PLAN EXAMINATION RFI HOLD

Maine Medical – East Tower 6 & 7th Floor Addition with Helipad

22 Bramhall St – Portland, Maine

Plans Date: 3/9/18

Drawing file: 04 - Architectural / A32-01 EXTERIOR SECTION DETAILS - TYPICAL.pdf

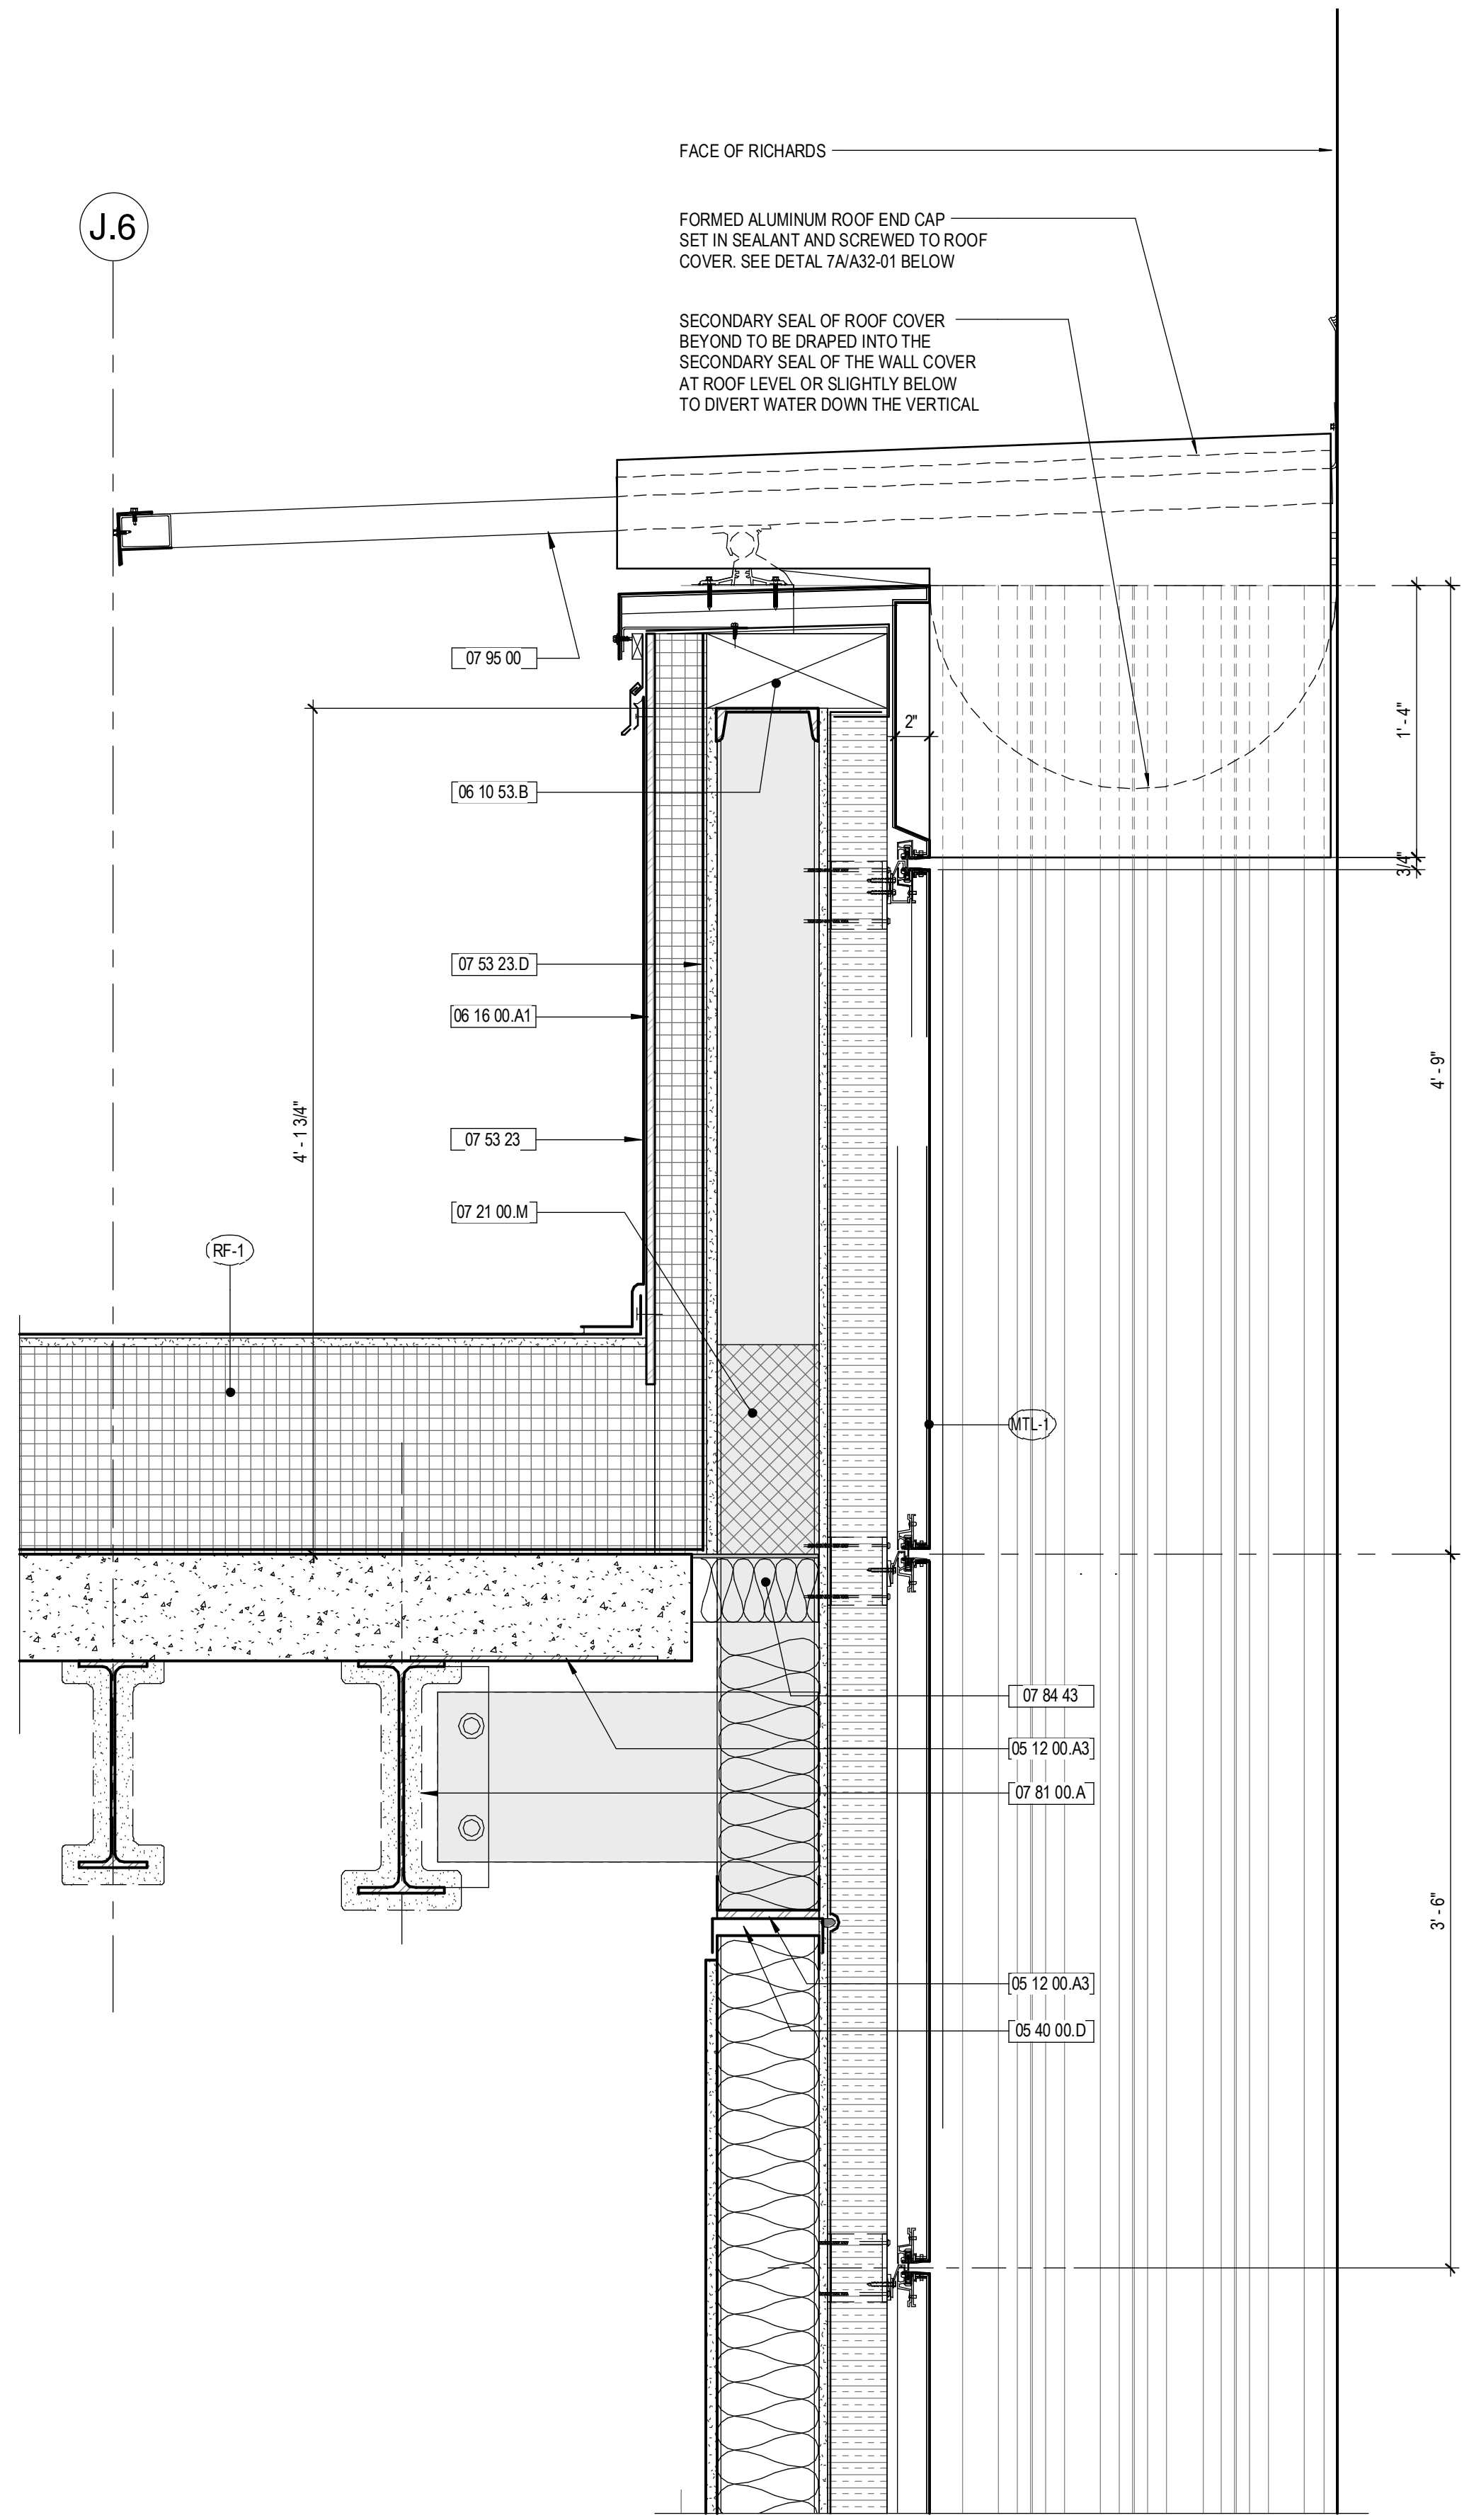
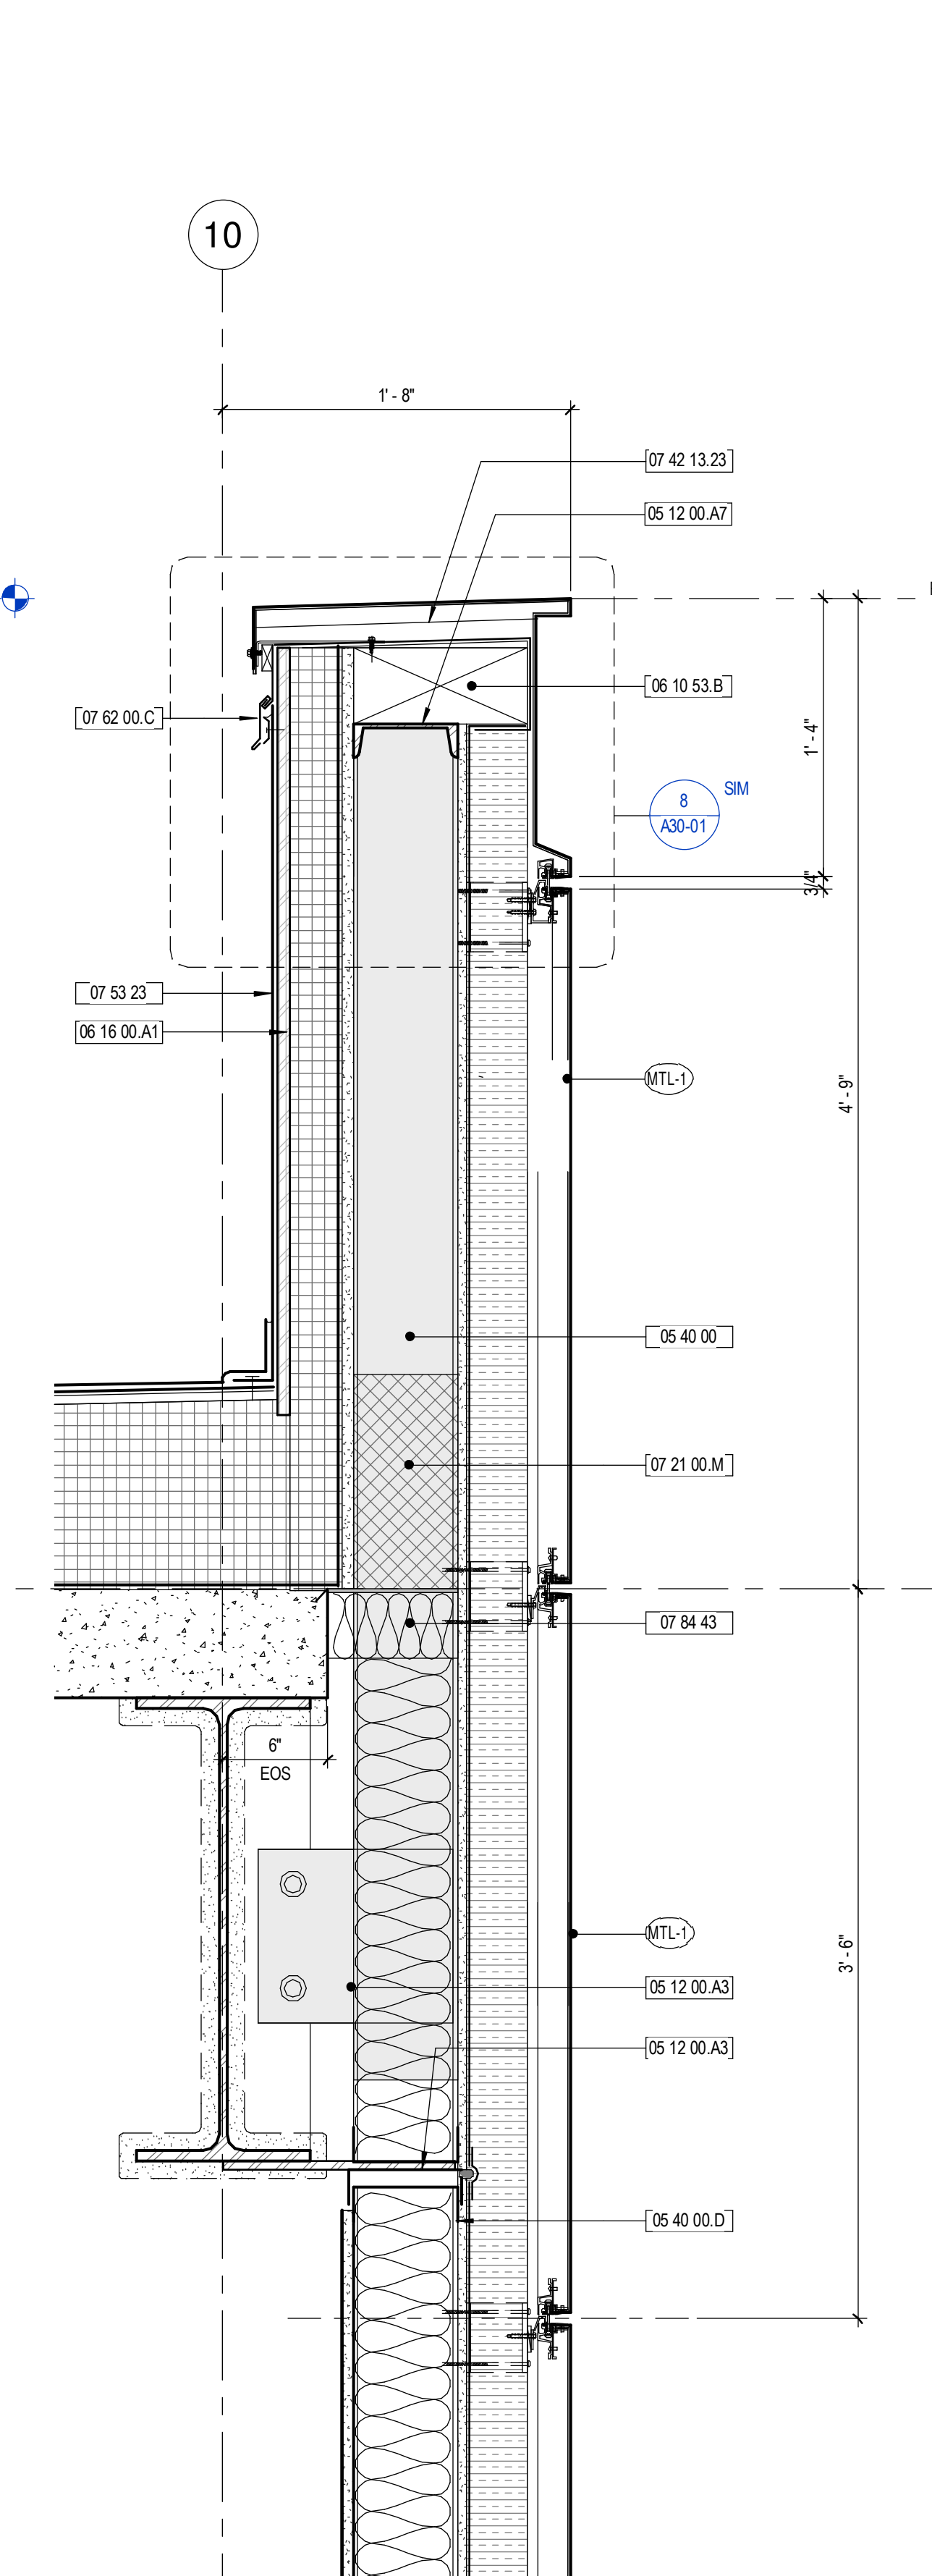
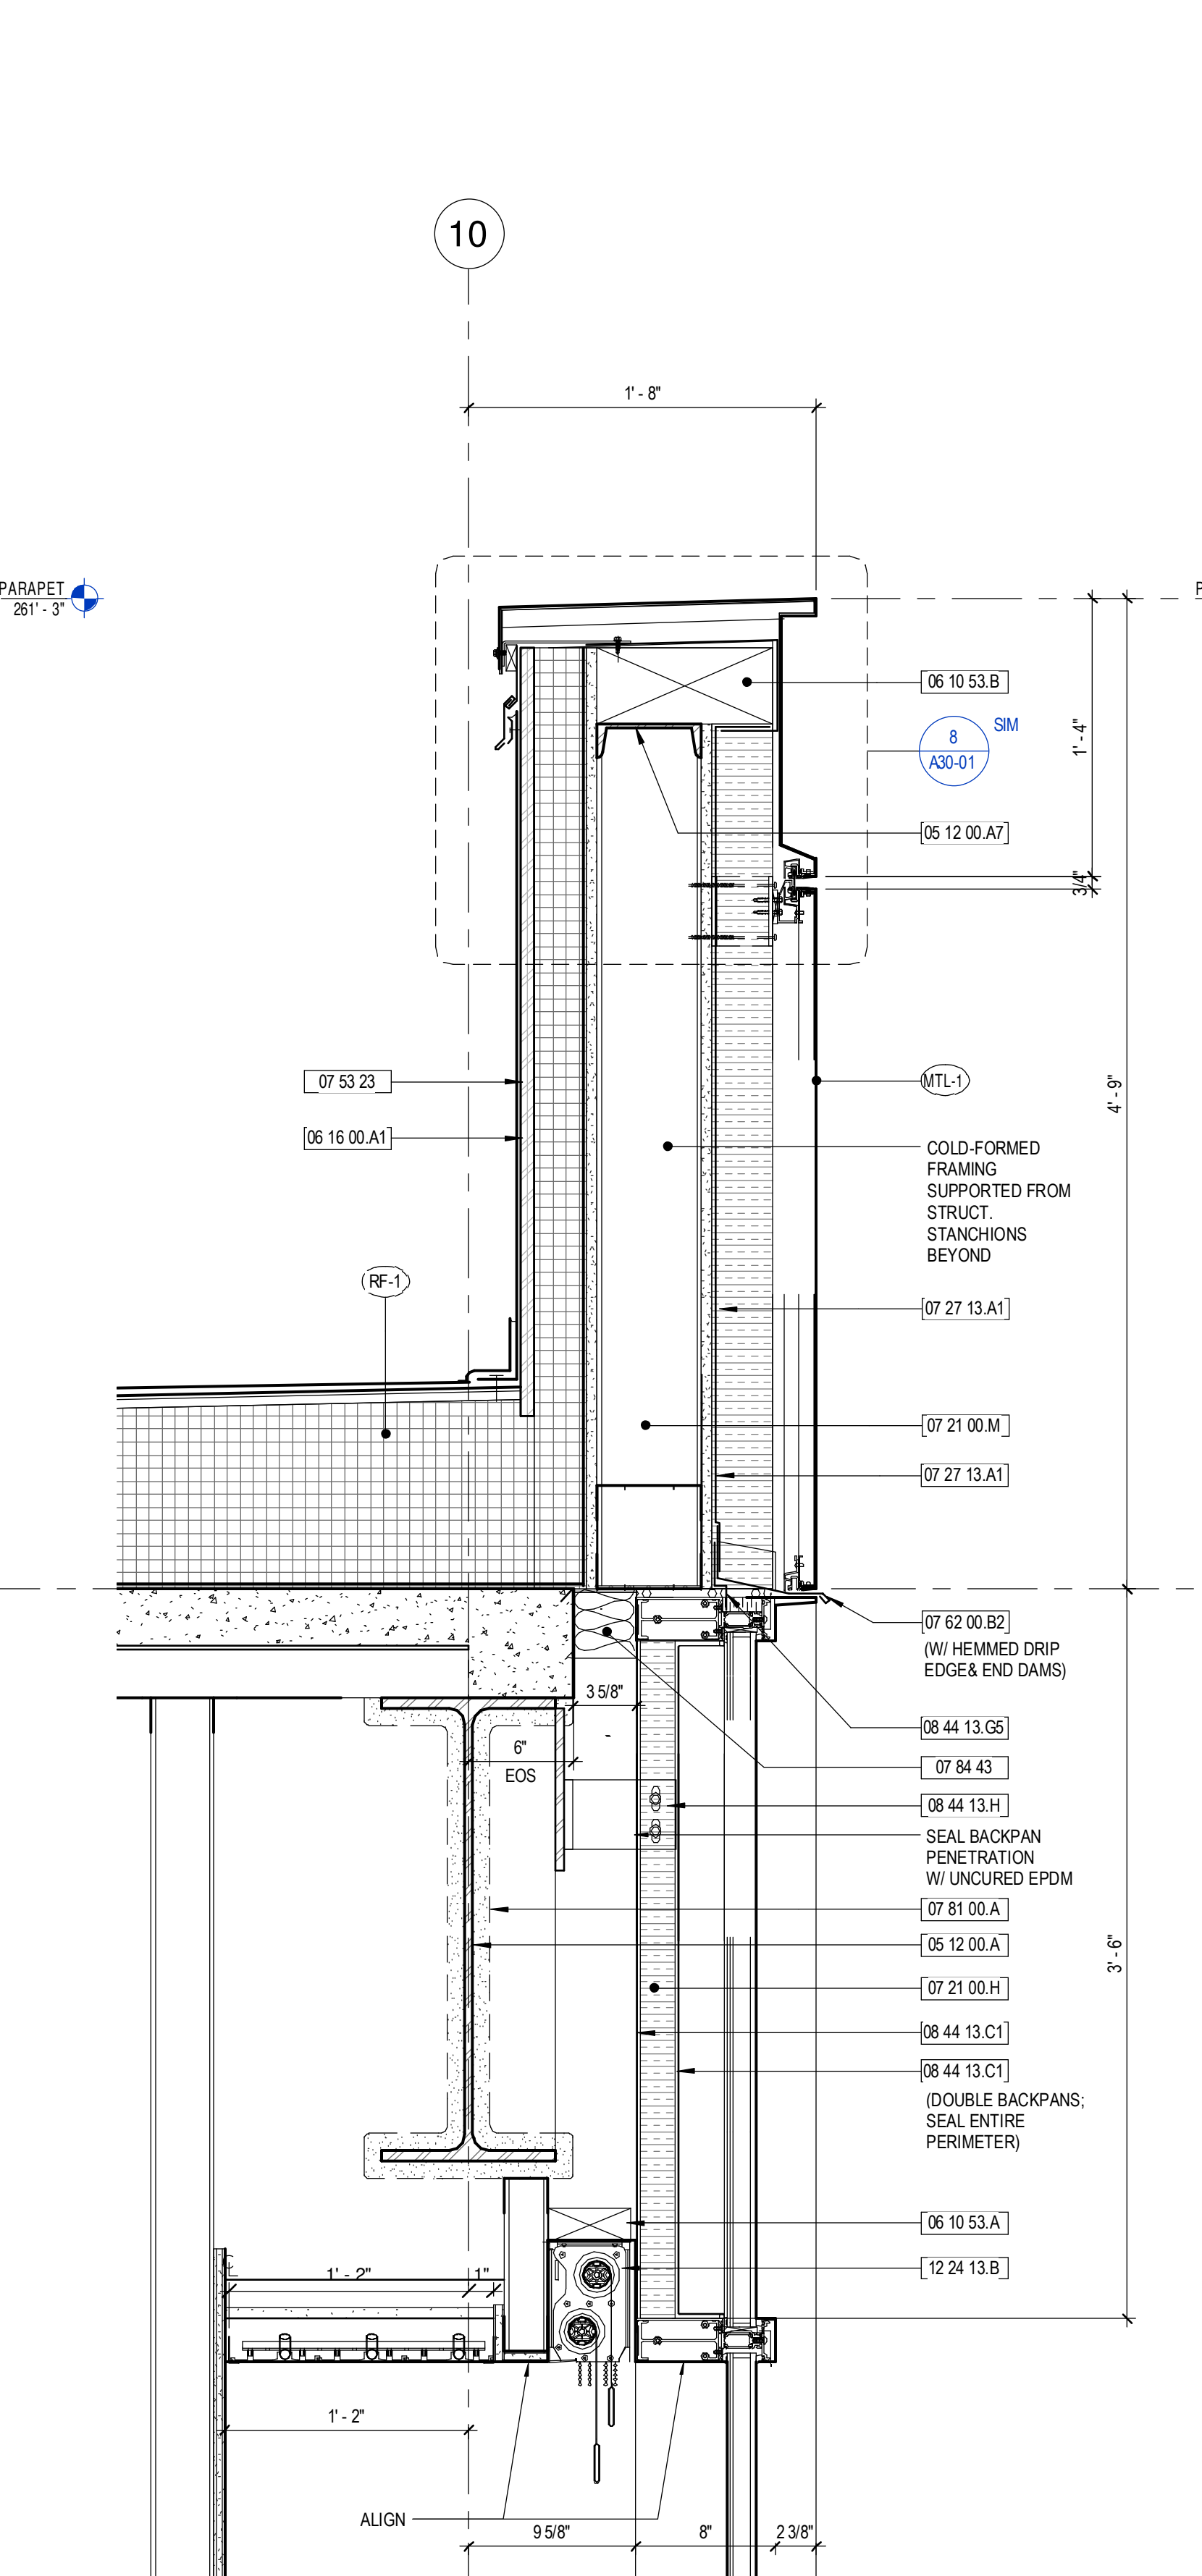
2. Provide the required fire-resistance ratings for the primary structural frame. A project code summary / analysis is not provided and the various details that show protected primary steel members (exterior section details on sheet A32-01 for example) note the protective material but do not provide a thickness or hour rating.
